CITY OF ELLENSBURG

Re: Vista View

We need to obtain additional information from you regarding the buffer area at the west end of Seattle Street which is located in the new Vista View Plat being constructed by MDJ Development. The plans show that the road improvements stop 50' short of the end of the plat boundary.

SEATTLE AVE

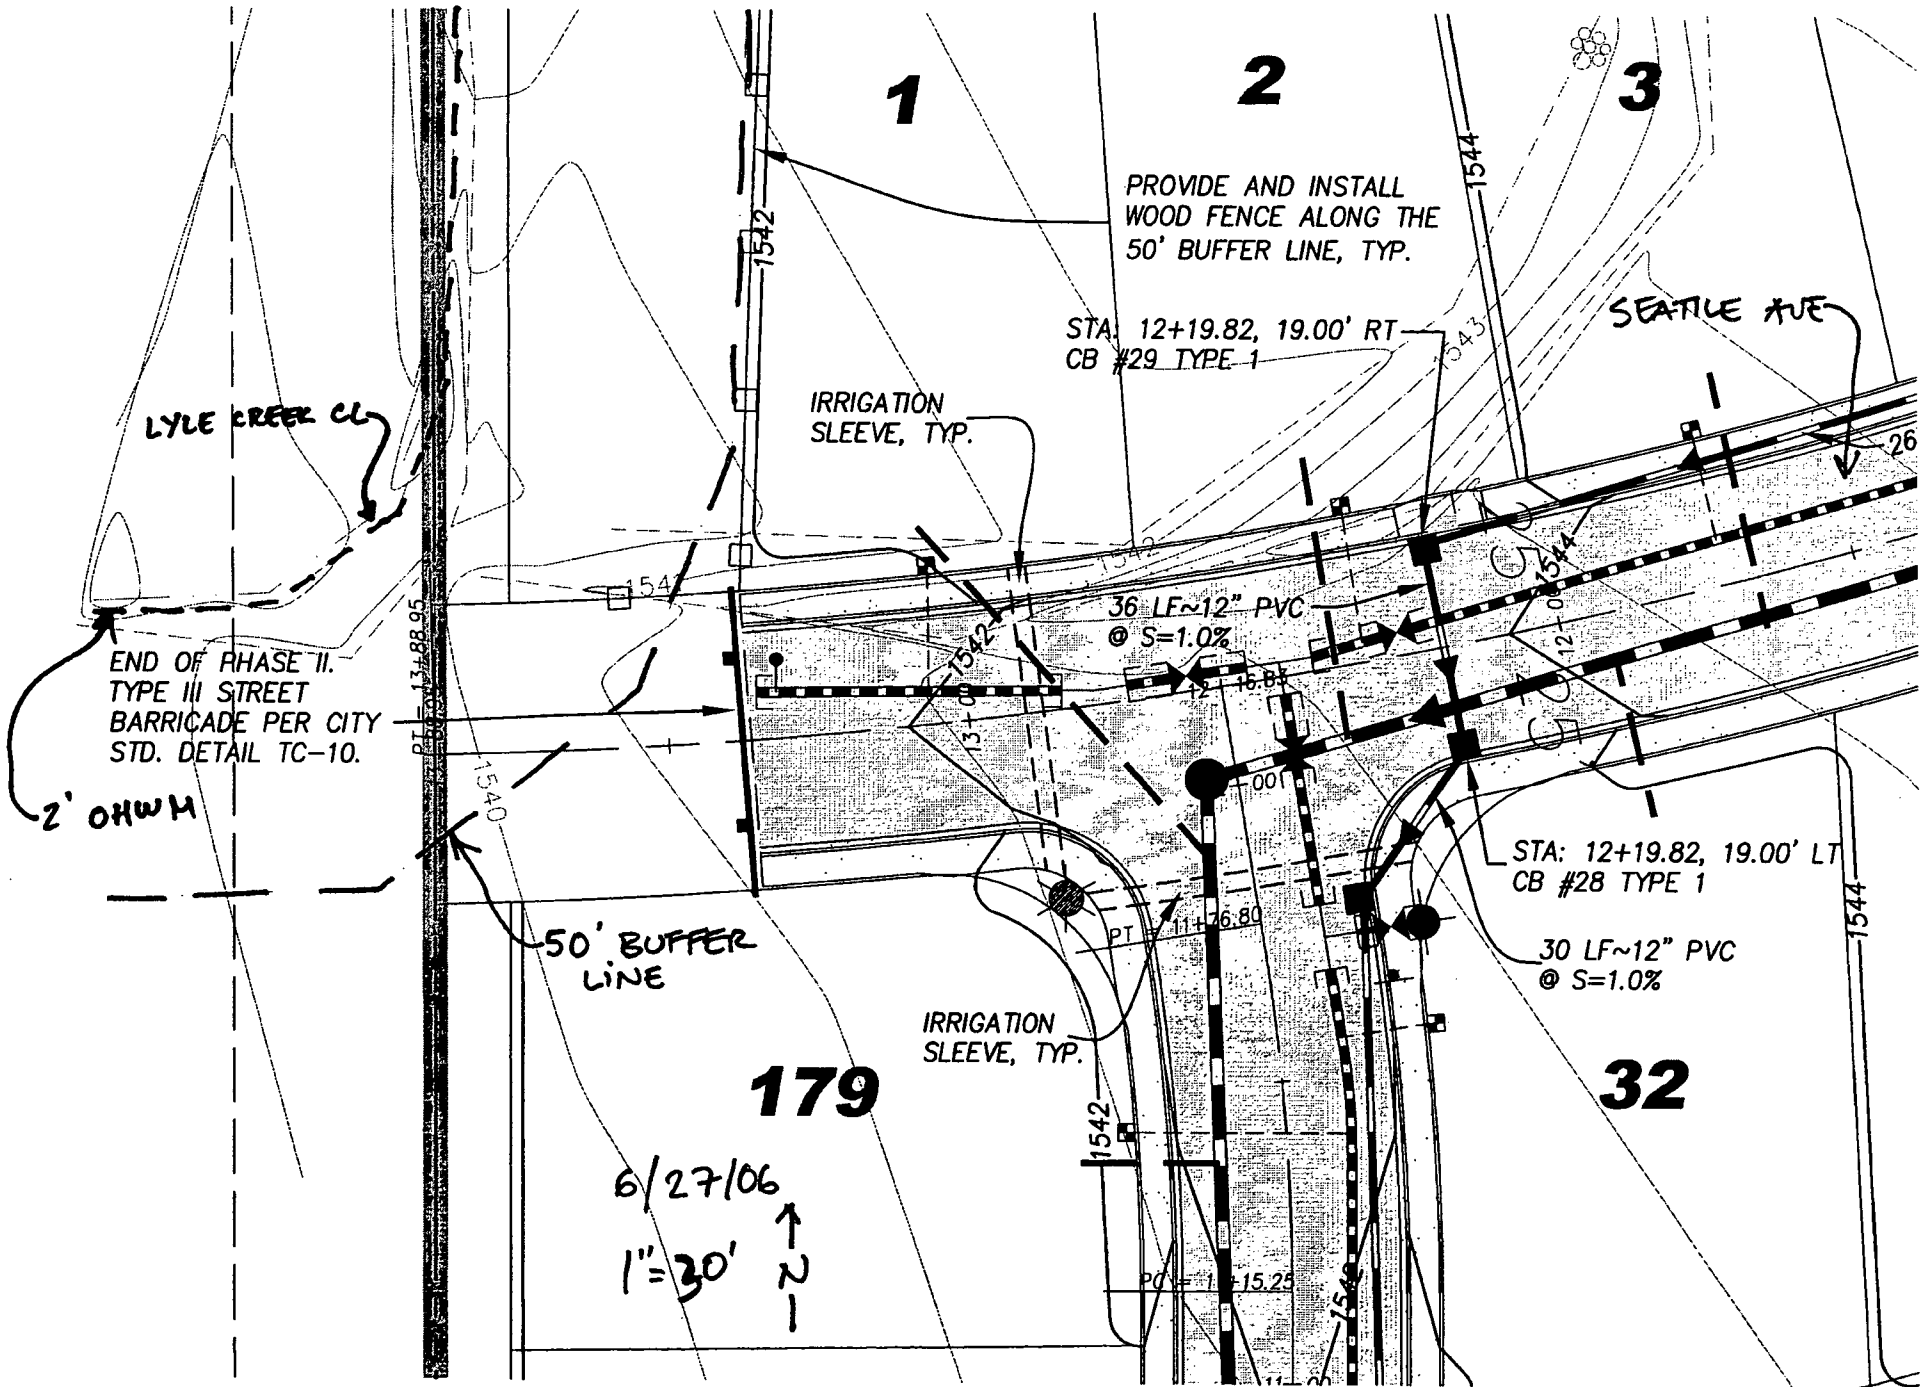
The City of Ellensburg requires that roads be completed along the frontage of all parcels being developed. Meaning that unless the road is completed to the full extent of the roadway on the north side of Lot # 179 the lot will not be developable.

Could you please let us know why the road is not drawn to the end of the property on the civil drawings and if it can be please contact MDJ Development so they can advise their engineer to do so.
